Application Reference: 2025/0513

Site Address: 16 Maple Close, Kendray, Barnsley, S70 3NN

Introduction: Erection of detached garage

Maple Close, Barnsley
Garage Elevation & Sections
Scale - A2 @ 1:50
12/01/256
Rev A

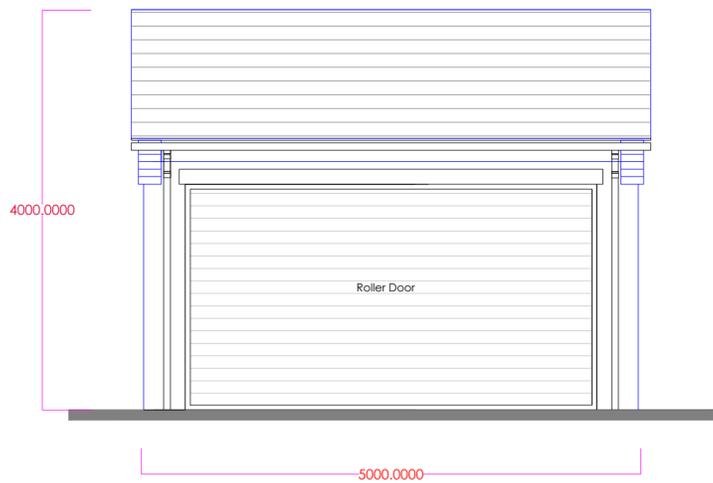
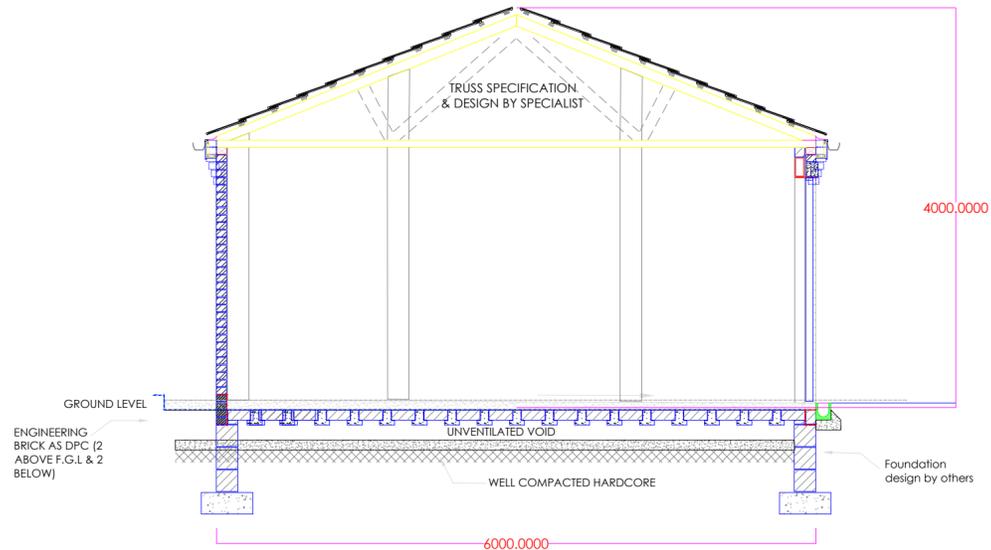
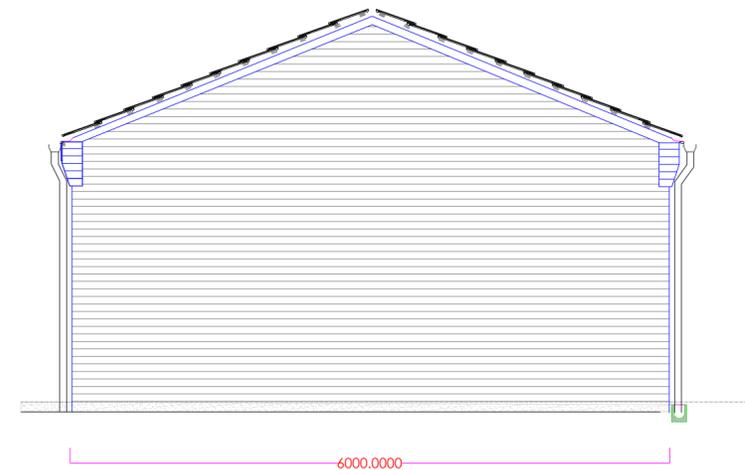
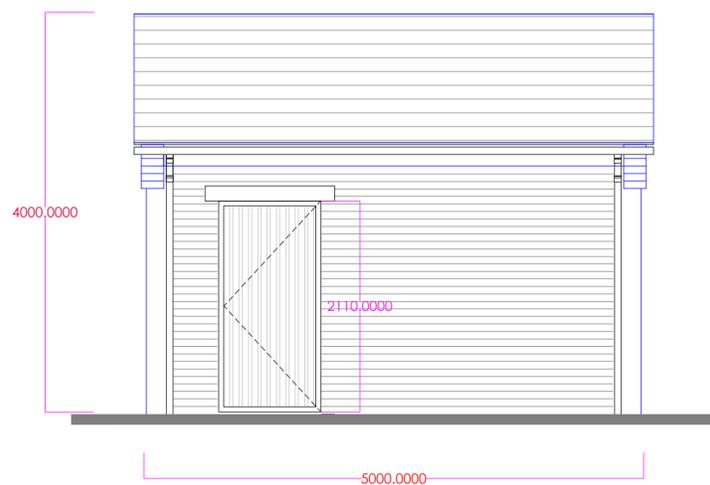
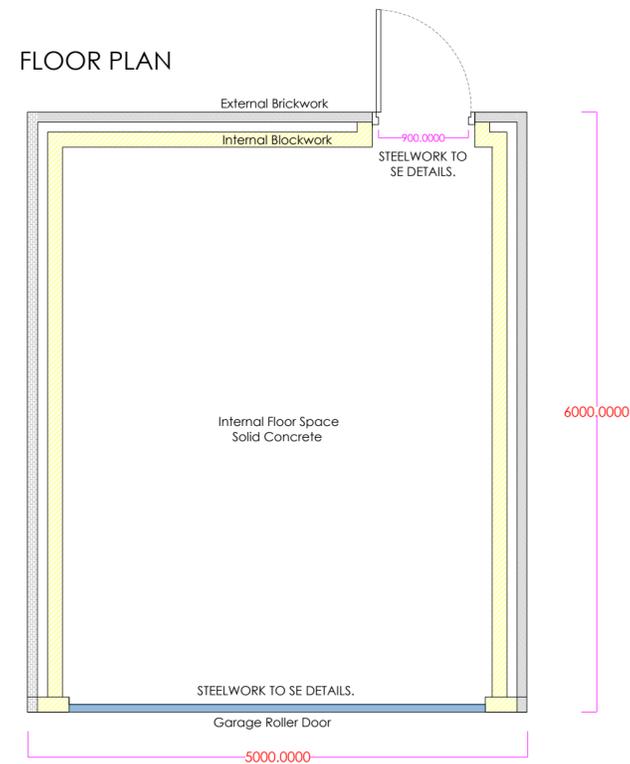
The proposal would provide a pitched roof with an eaves height of 2.6 metres and a ridge height of 4 metres. The use of a pitched roof allows the proposal to remain in keeping with the character of the site and the street scene. The ridge height of 4 metre is acceptable as set out in the house extensions SPD and although the eaves height is larger than what is outlined in the house extensions SPD, given it only exceeds the required 2.5 metres by 0.1 metre, this increase is small enough to be considered acceptable.

The garage would be erected to the North of the side elevation of 18 Maple Court and separated by a parking area. Therefore, is unlikely to have a significantly negative impact on neighbouring amenity in terms of loss of outlook/light or be of an overbearing nature. Additionally, no side elevation windows have been detailed to the garage preventing opportunity for overlooking.

The proposal would not increase the number of bedrooms on site. Due to the internal size of the proposal, the garage is only considered to provide 1 parking space. The application has been amended to allow for parking to the front of the garage, allowing for a second parking space. The proposal details a roller shutter door. This allows for sufficient parking space to the front of the garage which will not be impeded by the opening and closing of the garage door.

It has been necessary to make contact with the applicant to make amendments to the positioning of the garage on various plans in order for the various plans to remain consistent with one another. Amendments were also requested to lower the height of the proposal, to detail a singular roller shutter door and further plans were requested showing all elevations and plans of the proposal.
